RE: **Church's Chicken #695** – 5407 Central Ave. NW  
**Grading and Drainage Plan** for Building Permit

File **K11-D081**  
PE Stamp: 8/26/13

Based upon the information provided in your submittal received 8/29/2013, the subject Grading and Drainage plan cannot be approved for Building Permit. The following comments need to be addressed prior to approval:

C5.1

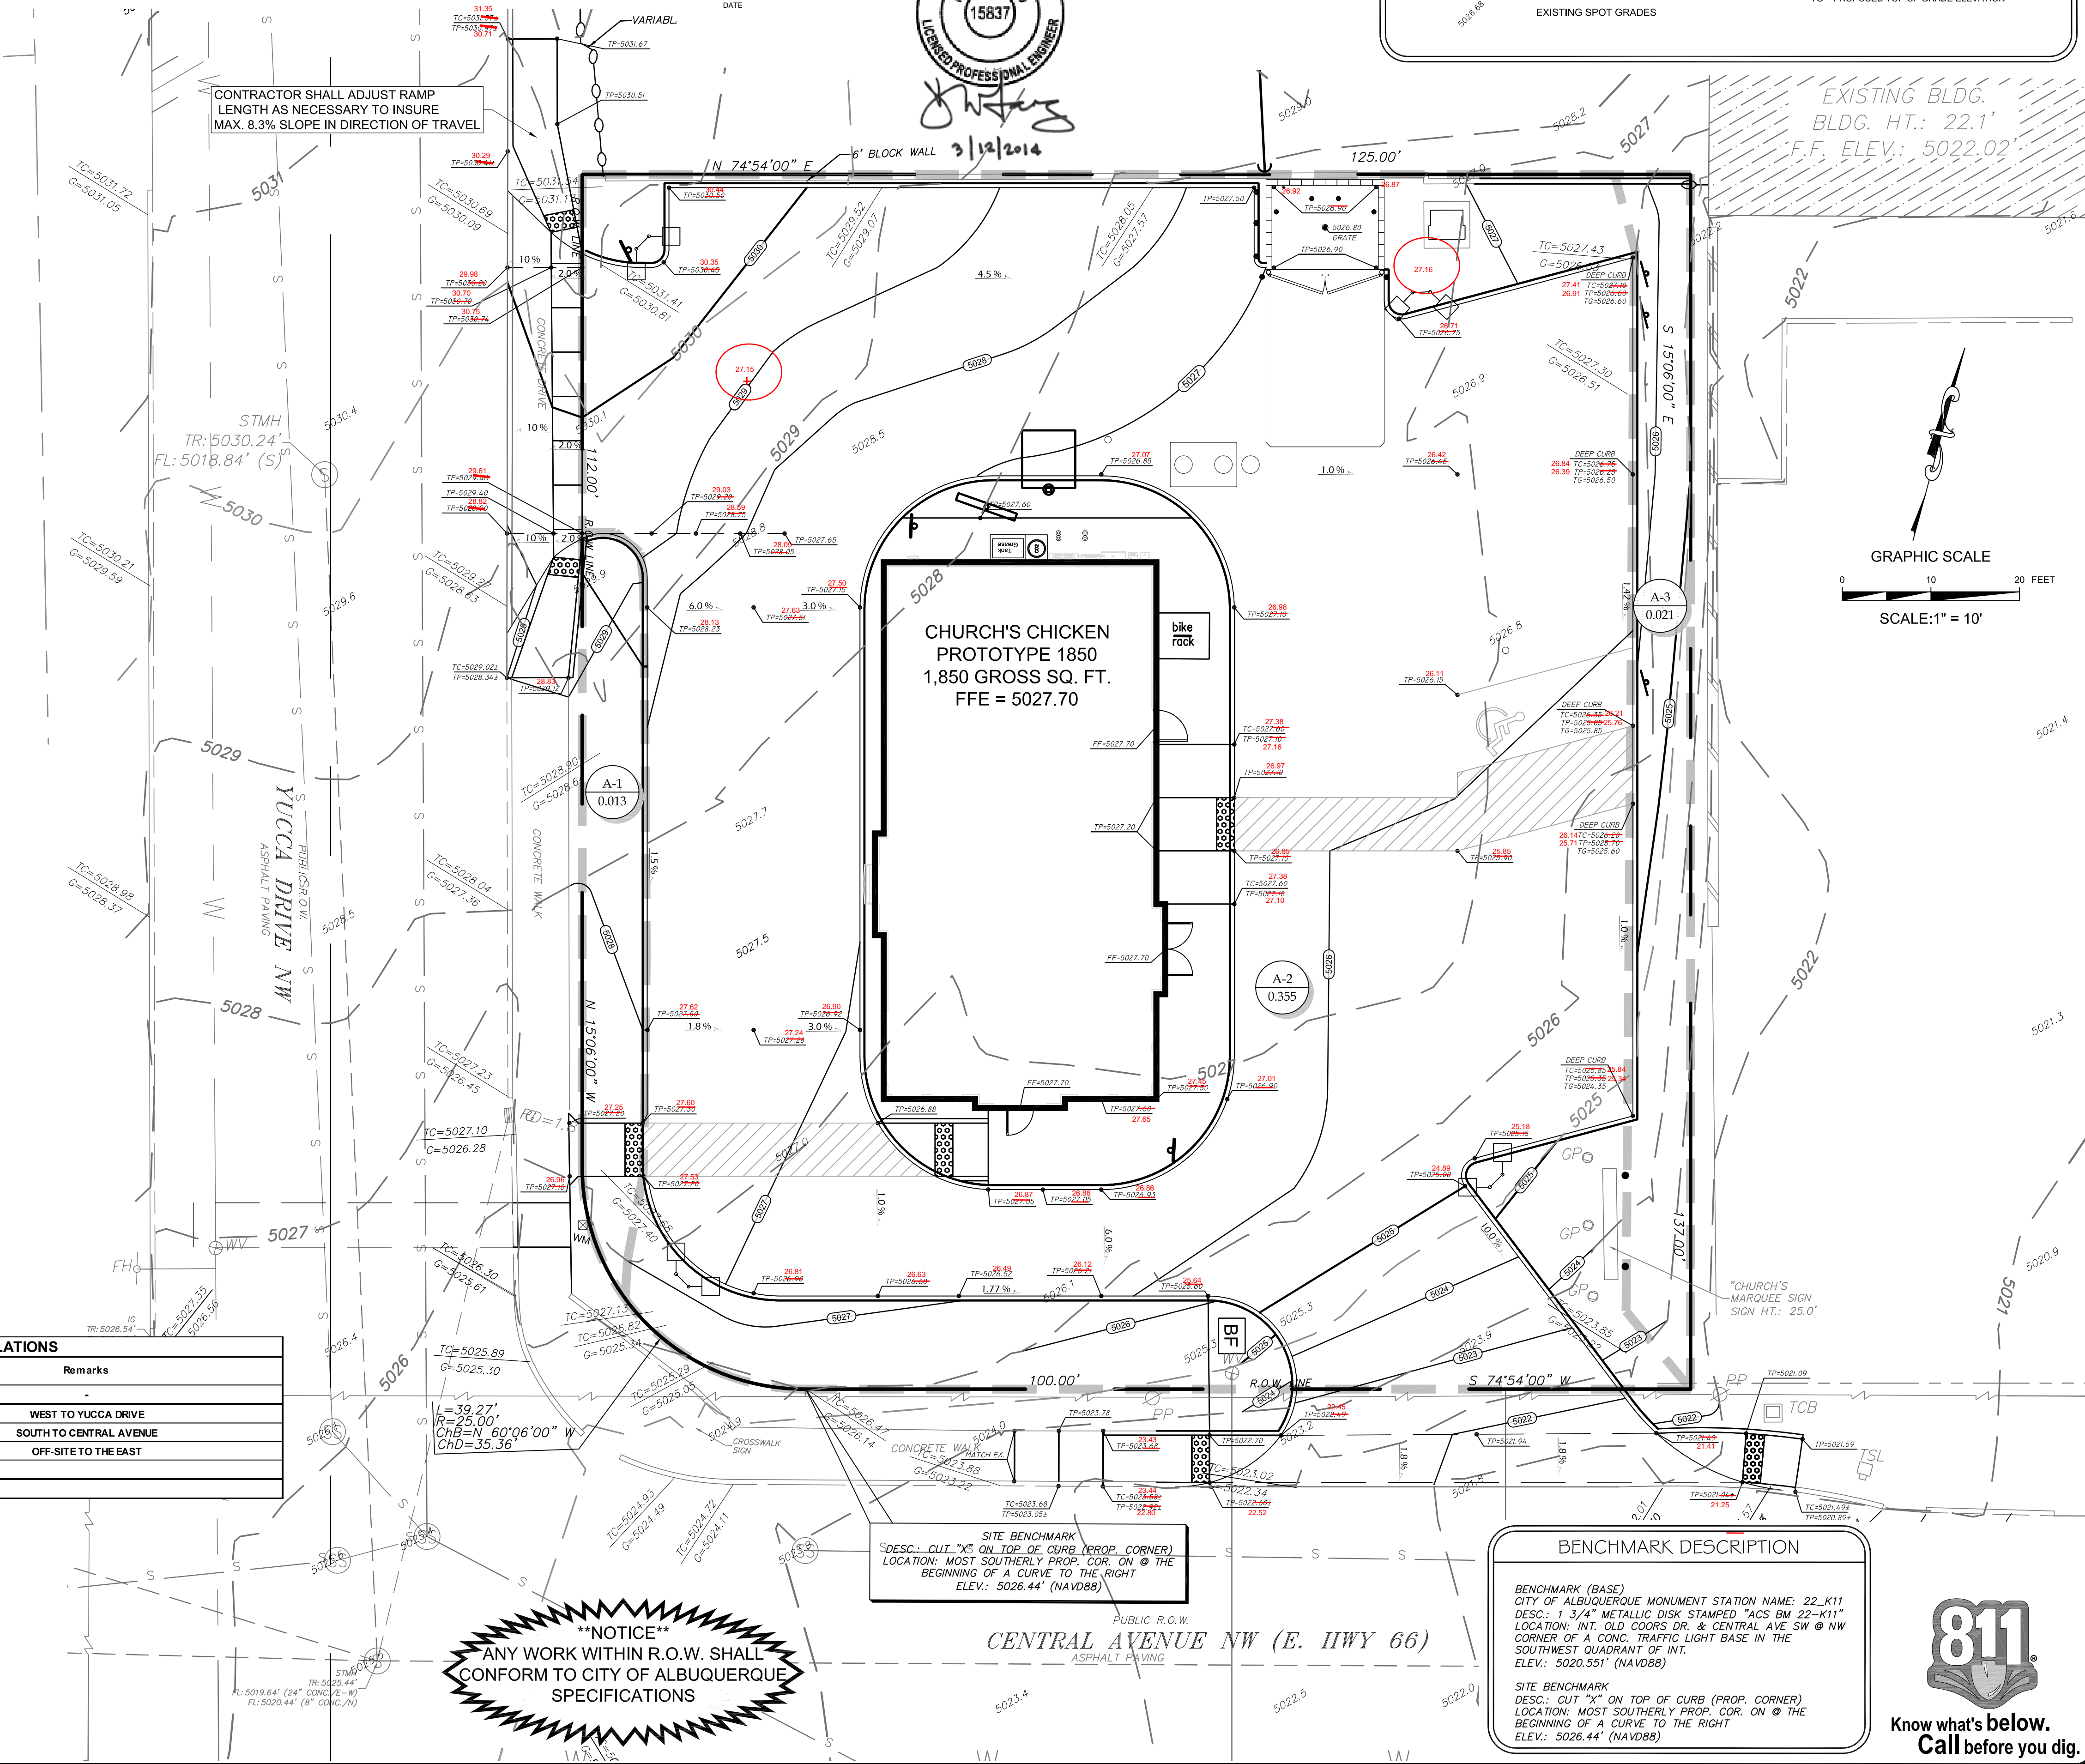
1. Wide Drainage Basin Boundary Lines used on this plan obscure some information critical to my review.
2. What is the “honey-comb” hatching in the area near the proposed dumpster?

3. Provide pad elevations at the dumpster pad showing drainage to the proposed floor drain, and provide reference to the drain, which is routed to a grease trap, as shown elsewhere on sheet \_\_\_\_ .

4. In advance of our Drainage Ordinance amendment requiring it, Hydrology Section *encourages* water Harvesting features in Grading Plans, such as depressed parking islands and landscape areas. Is there any way for you to route some of the parking lot flow through depressed landscaping areas?

5. Clarify how the 5' drop on the east side of the lot is stabilized to prevent erosion.
6. The west driveway entrance must include a water block to prevent street flows on Yucca from entering the site. As we discussed by phone, please consider alternate entrance designs, such as COA Standard DWG 24225 or 2428.
